From: Peter Cleveland
Sent: 13 February 2012 10:17
To: Planning.Responses
Subject: FW: Planning Application A/164/11 The Lamb, Angmering
Could the below email please be acknowledged as a consultation response.

From: Anna Appleton
Sent: 26 January 2012 11:48
To: Peter Cleveland
Cc: Graham Evans
Subject: Planning Application A/164/11 The Lamb, Angmering

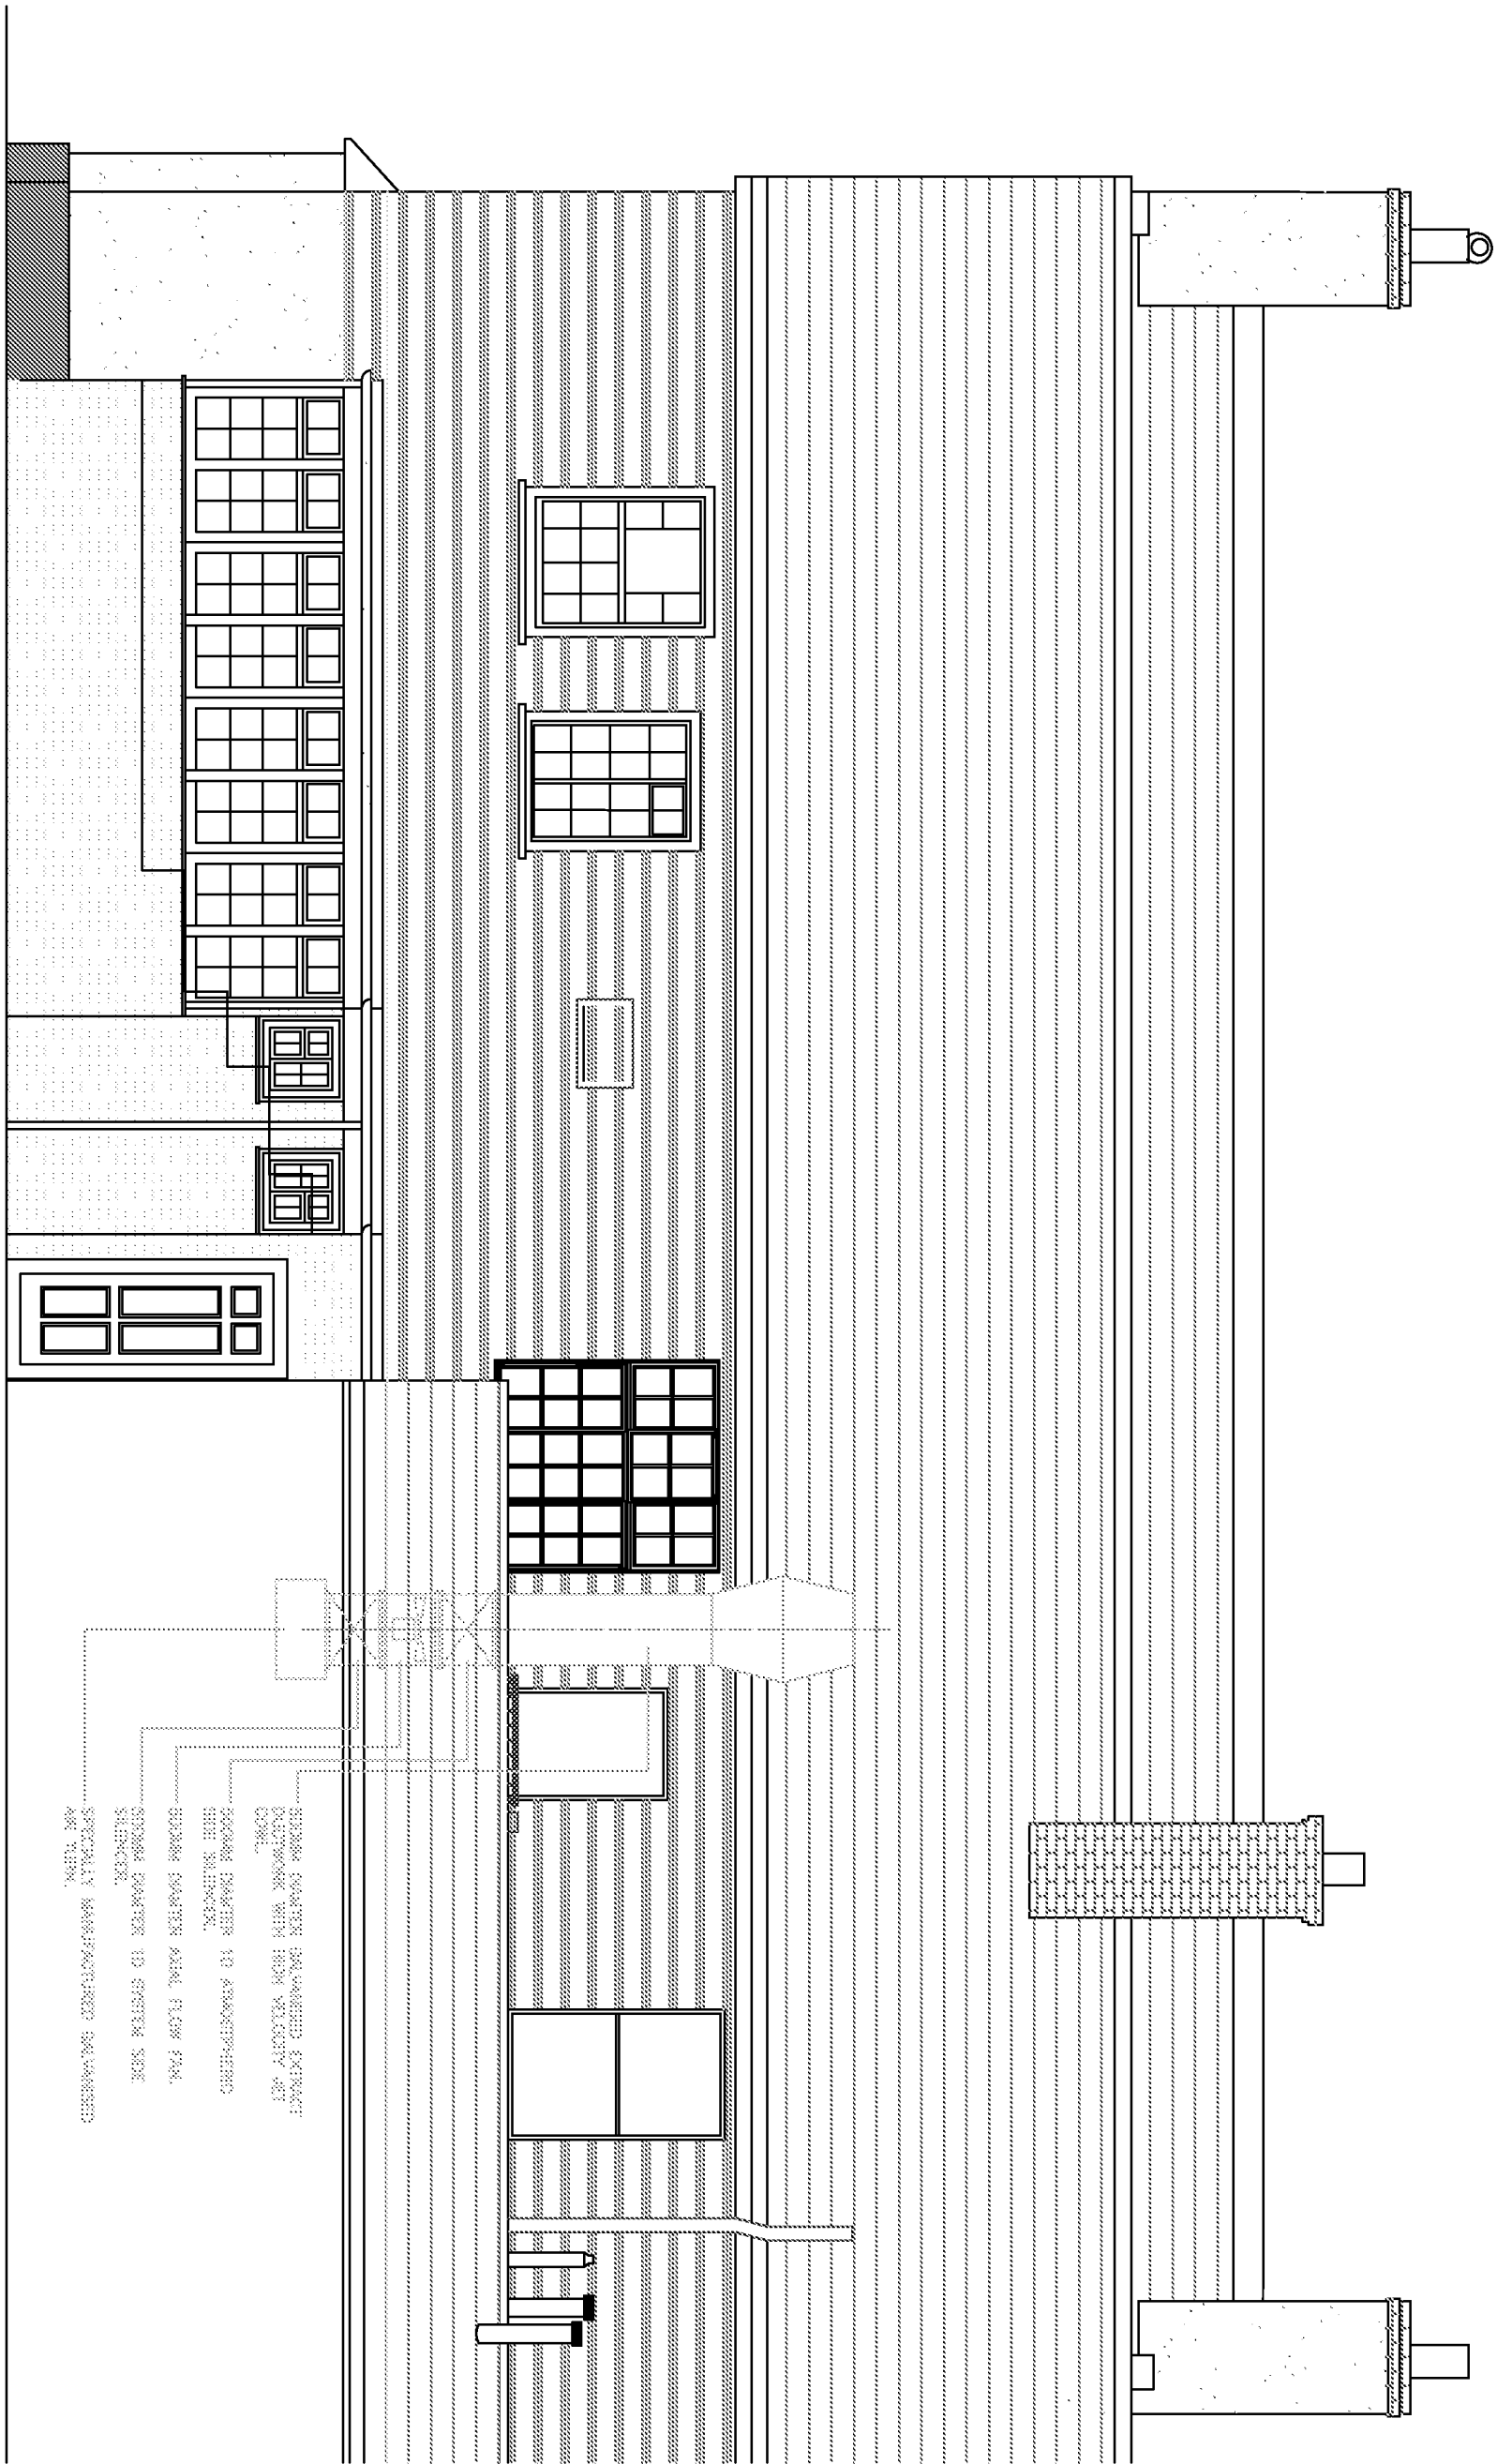
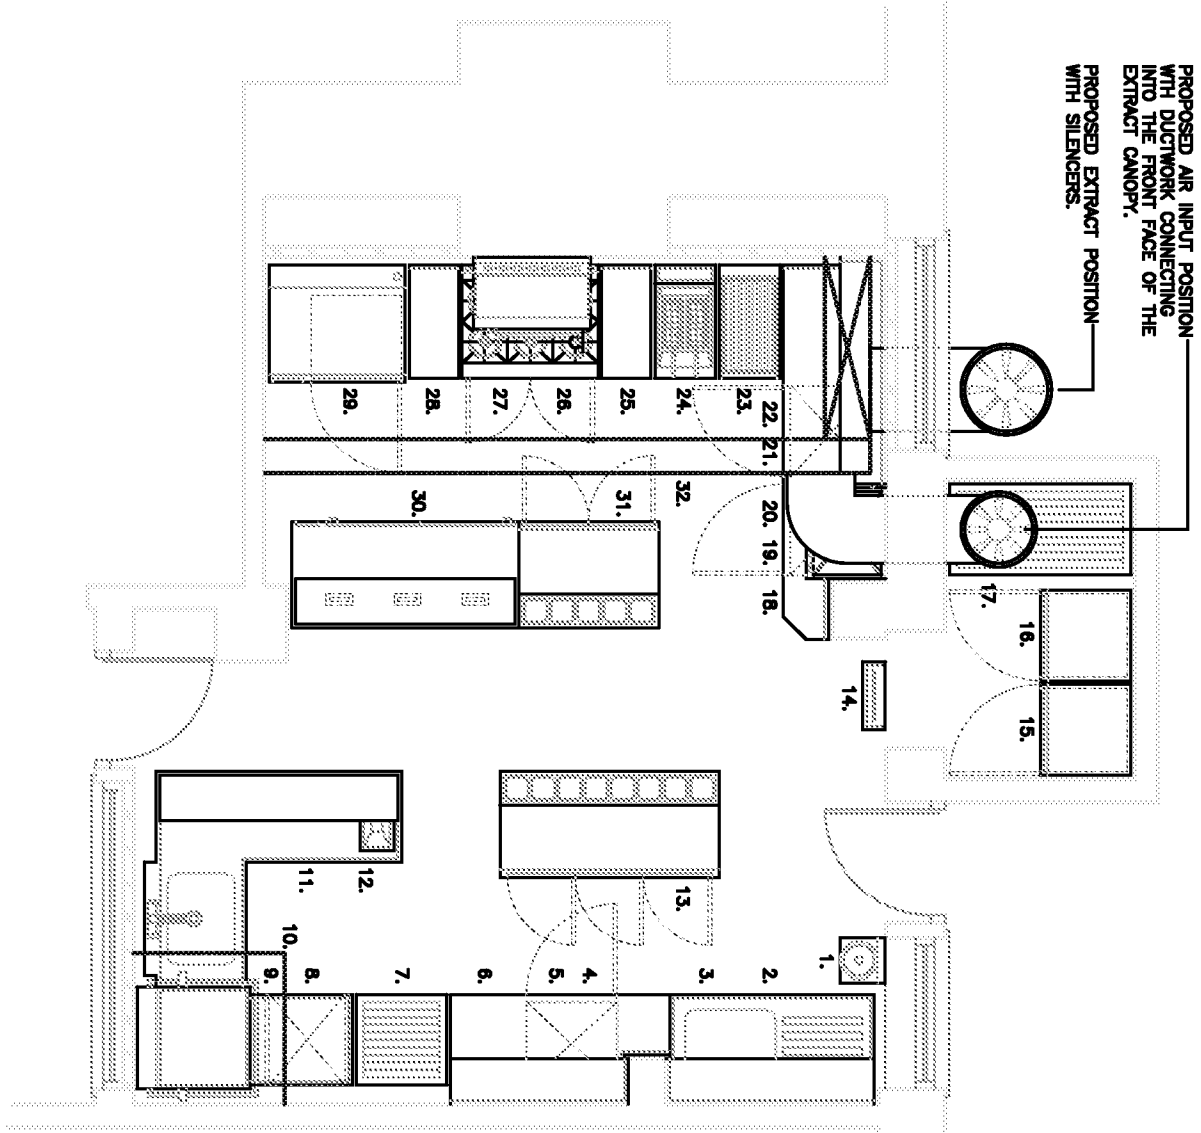
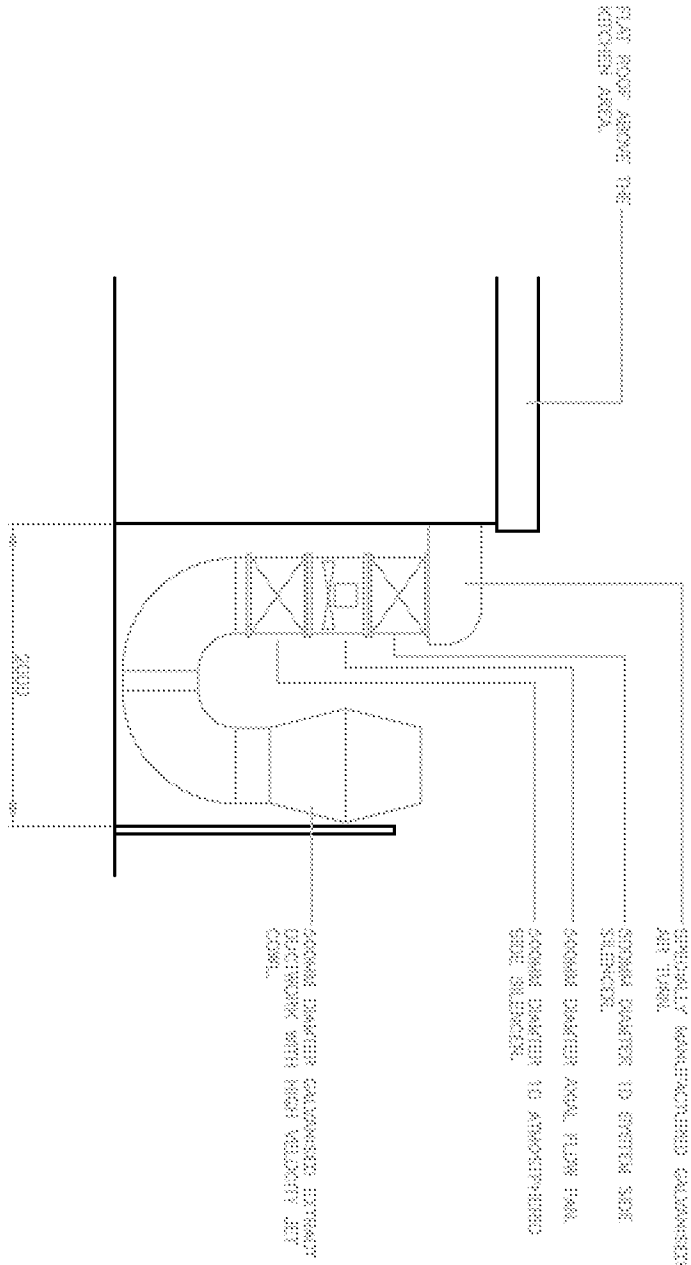
I note that they only intent to install baffle filters which are deigned to remove grease, with no plans for any additional odour control. However, I have spoken to Roy Robinson who is responsible for the installation of the kitchen ventilation system and he stated that the pub will be used for traditional pub food. The impact assessment for the premises indicates only low level of odour control should be required providing the pub provides traditional pub food and not high levels of fried food or other types of cuisine.

As such the filtration suggested should be adequate, providing the applicants can confirm the type of cooking to take place at the premises.
